DECISION DELEGATED TO HEAD OF PLANNING

Application No: H01-0779-24 **Applicant:** S Clarkson

Proposal: Proposed single storey rear extension & internal alterations

Location: 83 Backgate Cowbit Spalding

Proposed Rear (W) Elevation
1 : 100

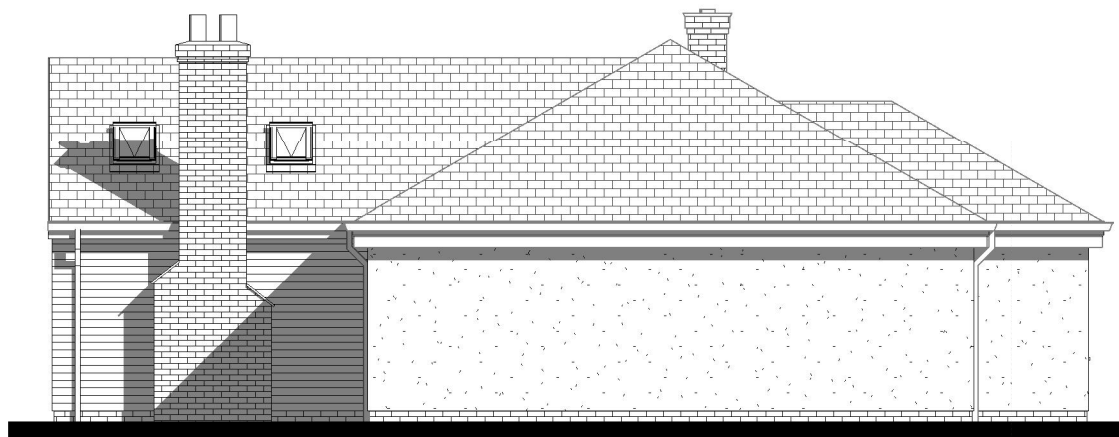
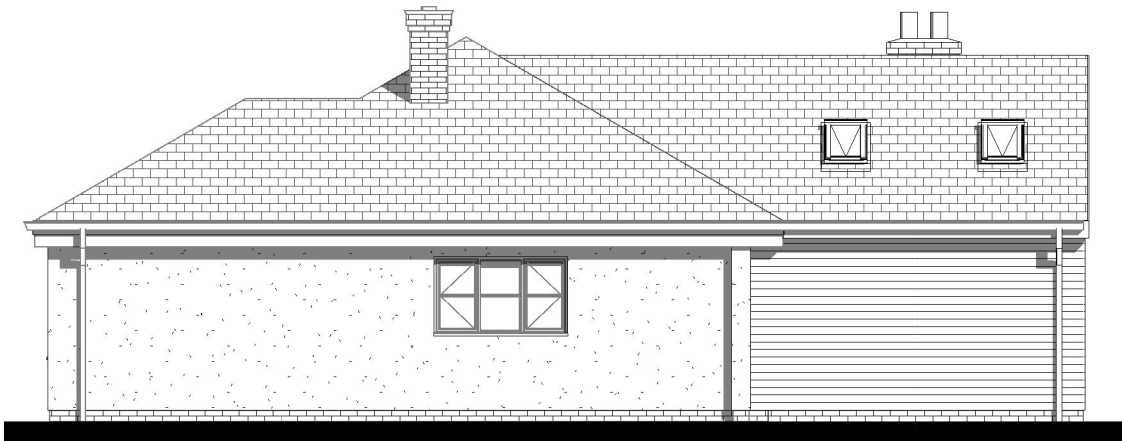
The application seeks consent to remove an existing small extension on the rear of the dwelling, and in its place a single storey rear extension is proposed. The extension is proposed to feature a gable end roof form. This differs from the main bungalow which features a hipped roof form, however, this is acceptable in this case as there is a mixture of gable end and hipped roof forms along the street scene. Furthermore, the gable end would not be highly visible from the street scene.

The proposed extension would measure 4.16m from the existing rear elevation, and 7.14m in width. The proposed extension would measure 4.8m up to the ridgeline and 2.3m up to the eaves, which is smaller than the front part of the dwelling. The scale and form of the extension would be acceptable as the extension would be subservient to the main dwelling. Furthermore, the scale of the extension could be allowed through permitted development rights if similar materials were used.

The extension is proposed to feature cladding and the application seeks consent to render the front of the dwelling. The dwelling currently features brickwork and most of the nearby dwellings also feature brickwork. Notwithstanding this, 87 Backgate features off white painted brickwork and this dwelling is close to the site (there are two dwellings in between). 76 Backgate, on the opposite side of the road, also features render with mock Tudor beams. There is therefore no strict uniformity in terms of the materials within the street scene and the proposed render and cladding is acceptable in this case. The cladding for instance would not be highly visible from the street scene as this would be located on the rear of the dwelling and would be most screened by boundary fencing.

One of the existing windows on the northern side elevation is proposed to be blocked up. There would still be sufficient light for this room as there is a window on the front of the dwelling that provides light for this room. The visual impact of blocking up the window is acceptable.

Two rooflights are proposed on the northern roof elevation of the proposed rear extension, and two rooflights are also proposed on the southern roof elevation. The visual impact of the rooflights is acceptable as they are evenly spaced and proportionate.

The bungalow currently features a chimney breast, and an additional chimney breast is proposed on the proposed rear extension. The additional chimney breast would therefore be located towards the rear of the site. The new chimney breast would not be taller than the existing chimney breast. The visual impact is therefore acceptable.

Proposed Rear 3D View

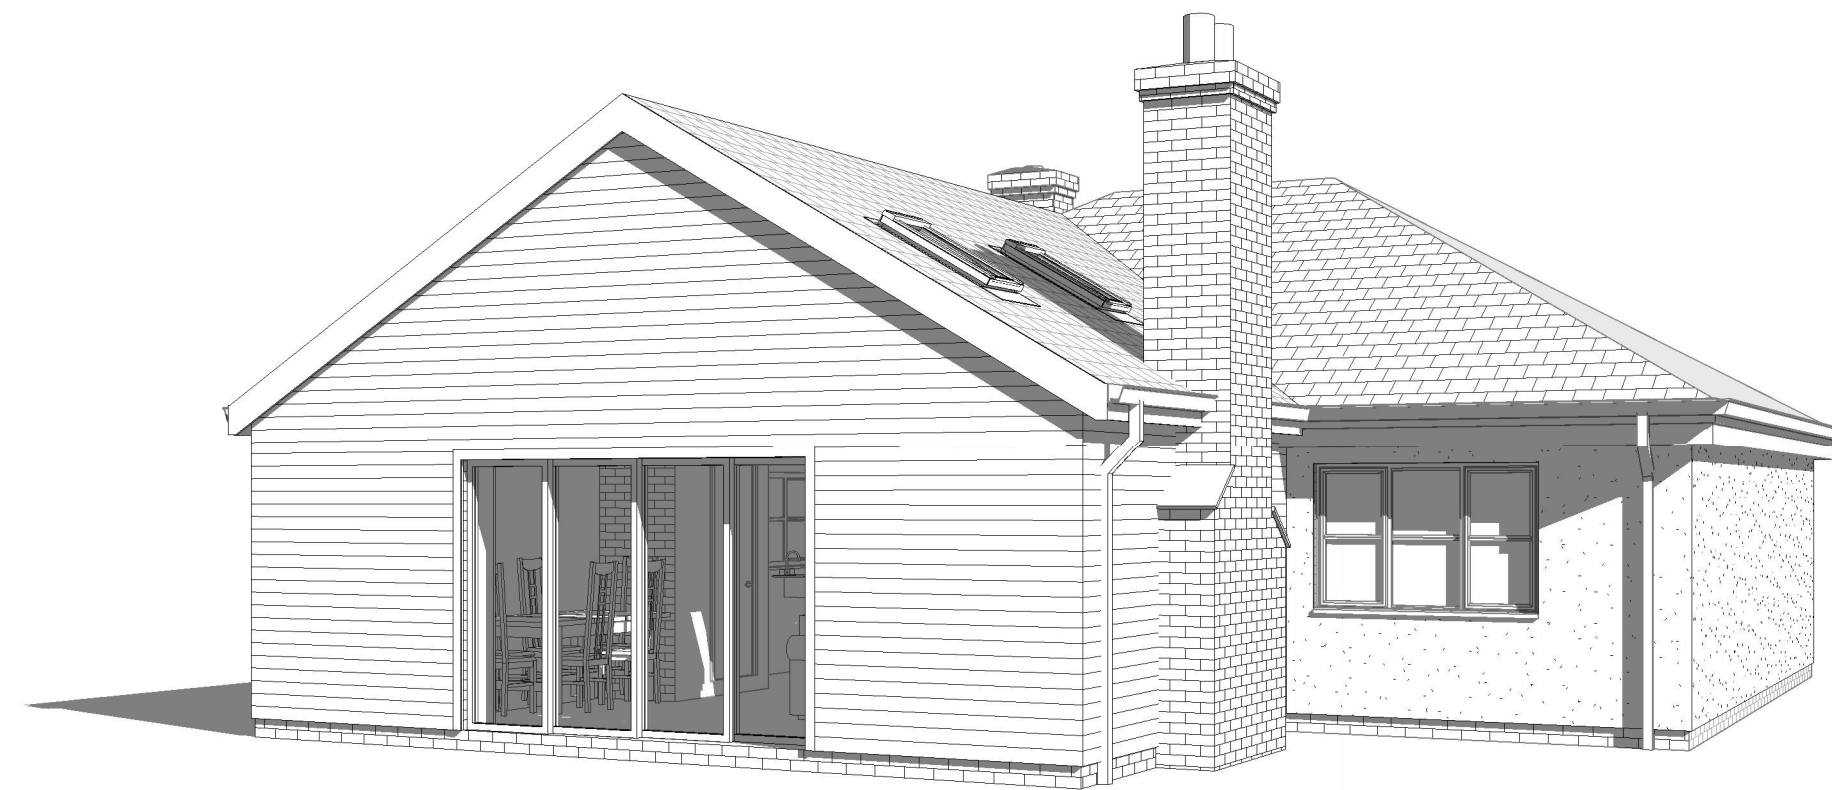
This representation set out concerns with the proposed fencing that appeared to be proposed on the 3D visualisations. It has since been clarified with the applicant's agent that the fencing is not proposed and was only shown indicatively on the 3D visualisation to block up the horizon behind the site.

It is noted that comments have been received from a neighbouring property setting out concerns with the proposed fencing and changes to the driveway that were shown on the 3D visualisations within the submitted plans. The applicant's agent has clarified that the fencing is not proposed and was merely shown indicatively within the background. The plans have subsequently been updated to remove the fencing and driveway from the 3D visualisations for clarity.

Amended plans have since been submitted to show only the dwelling for clarity.
